CITY OF ALBUQUERQUE

Re: NM Beef Jerky Restaurant
1425 4th St. NW, 87102
60-Day Temporary Certificate of Occupancy
Transportation Development Final Inspection
Engineer's/Architect's Stamp dated 8-21-17 (J14D185)
Certification dated 6-12-19

TCL
1 of 1

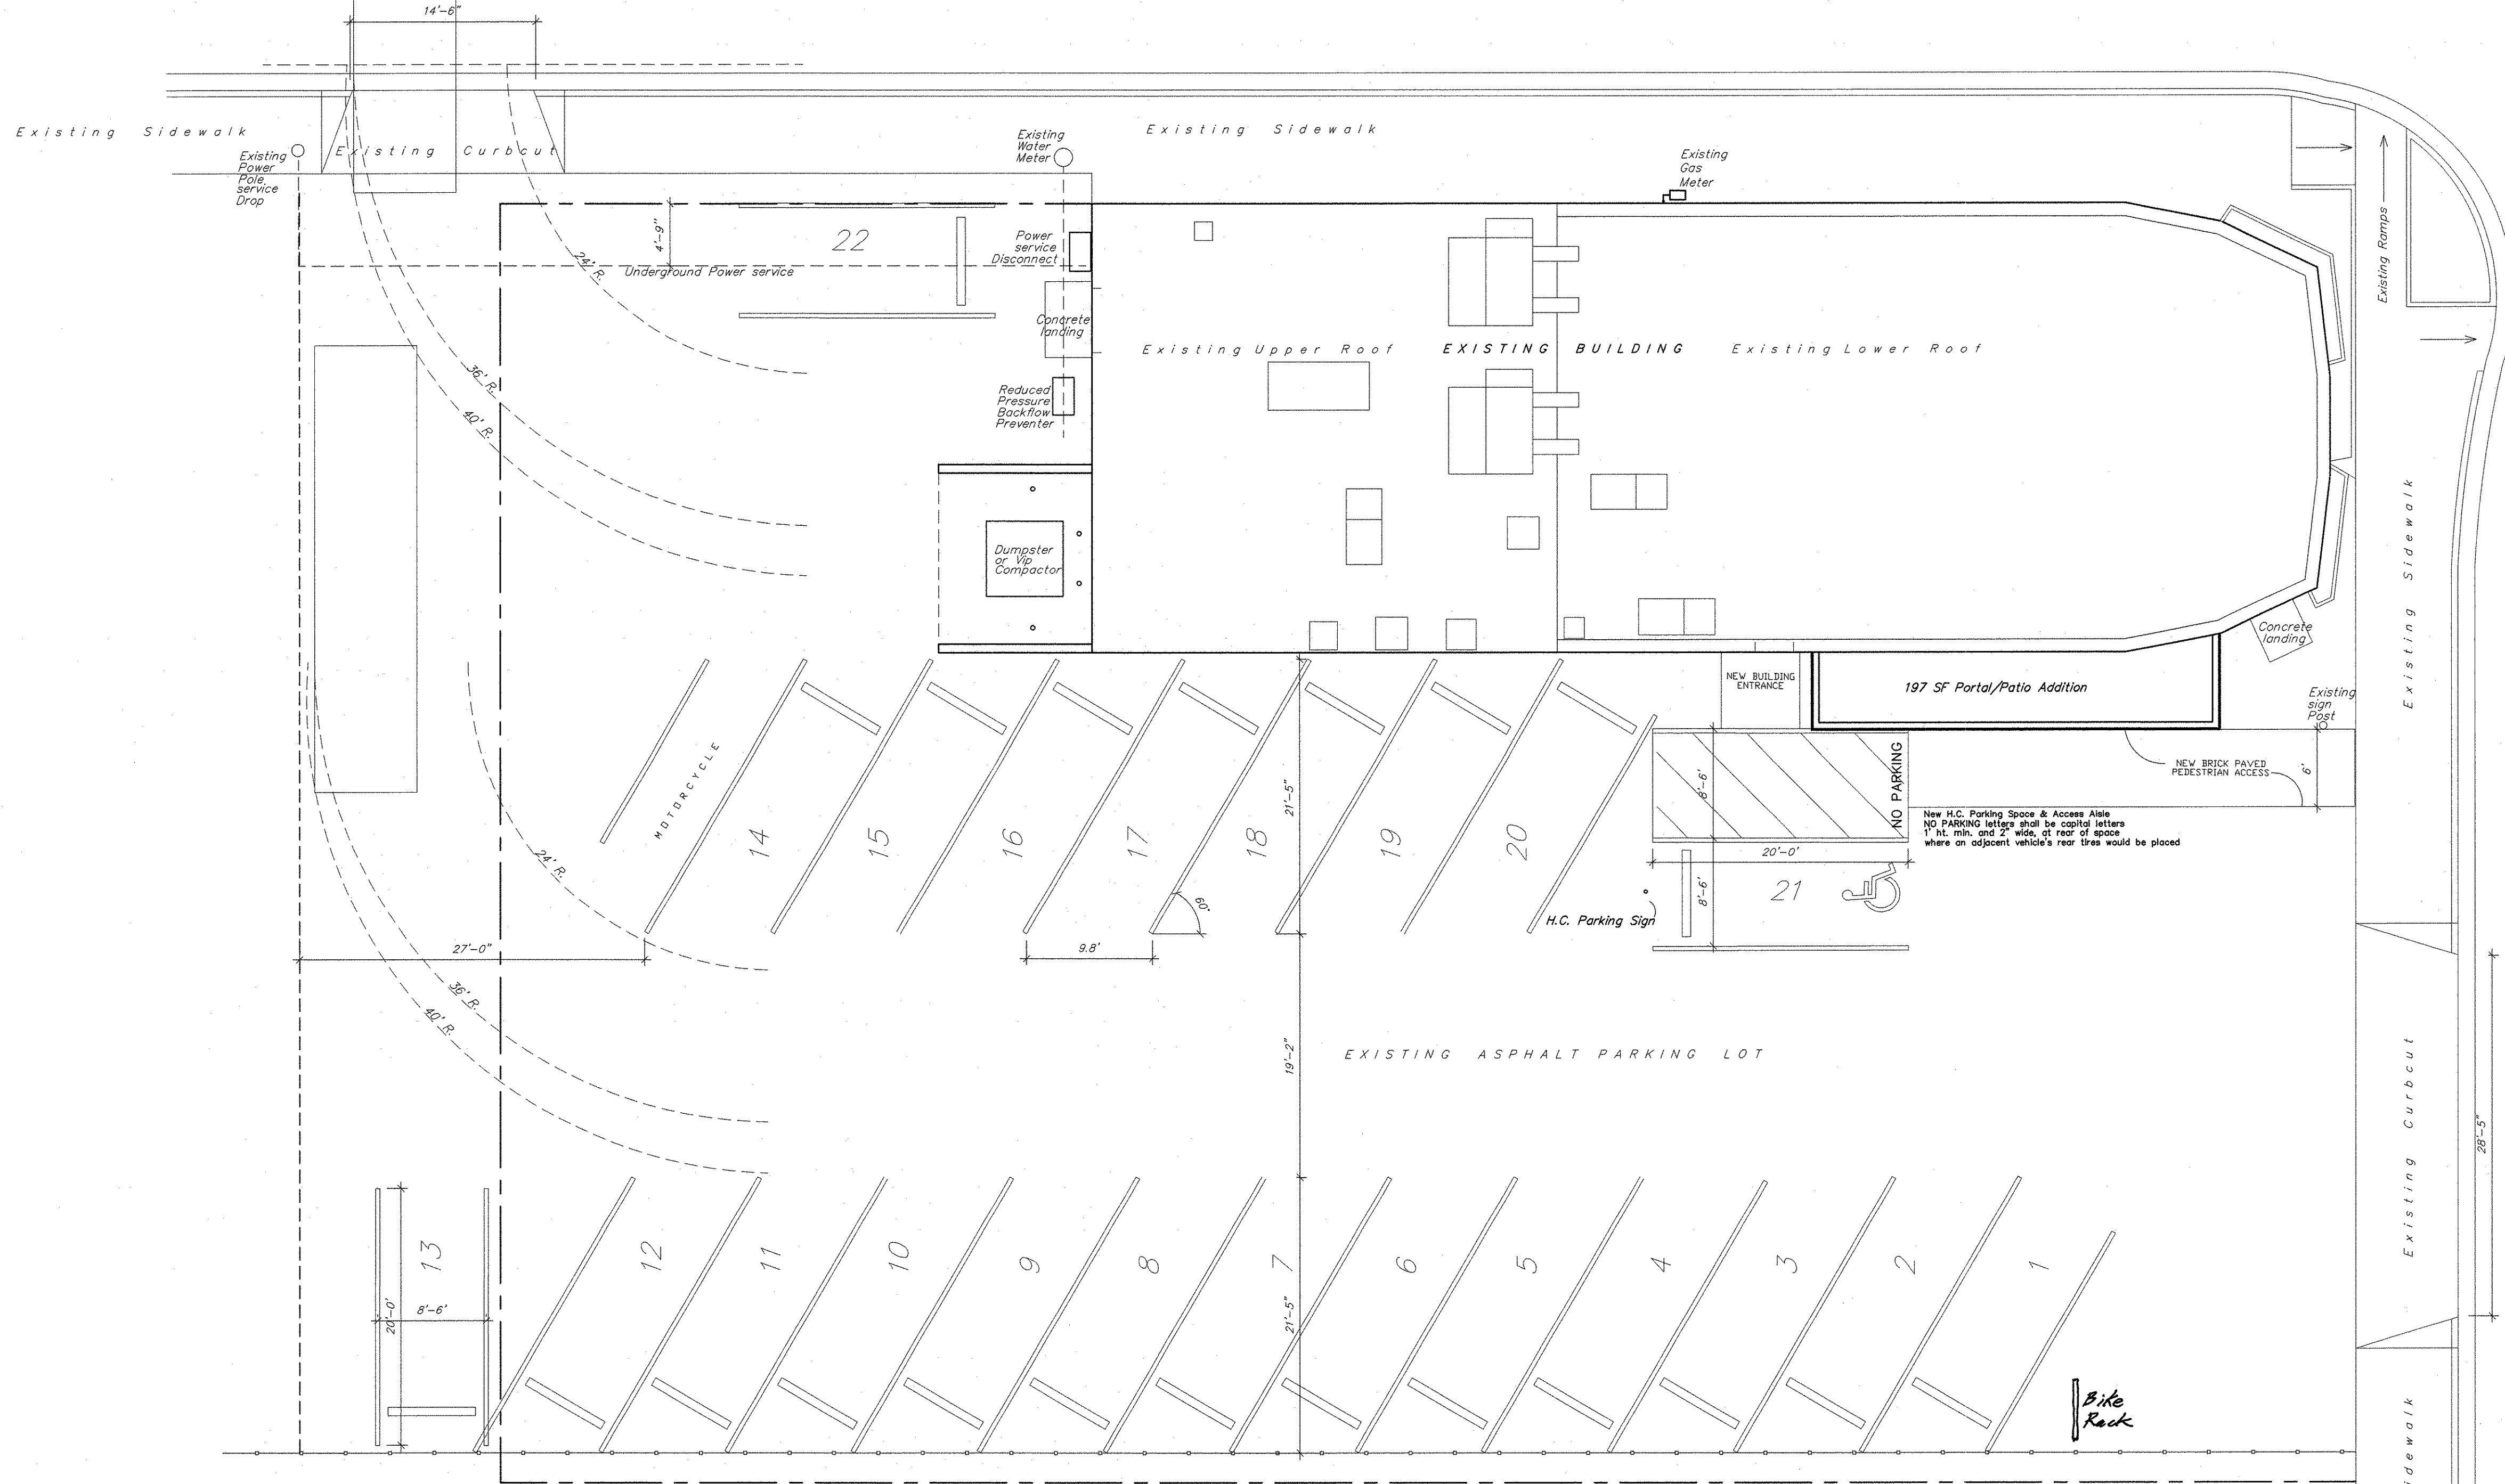
1. Please send pictures of Paved Alley. Or proof of Vacation.
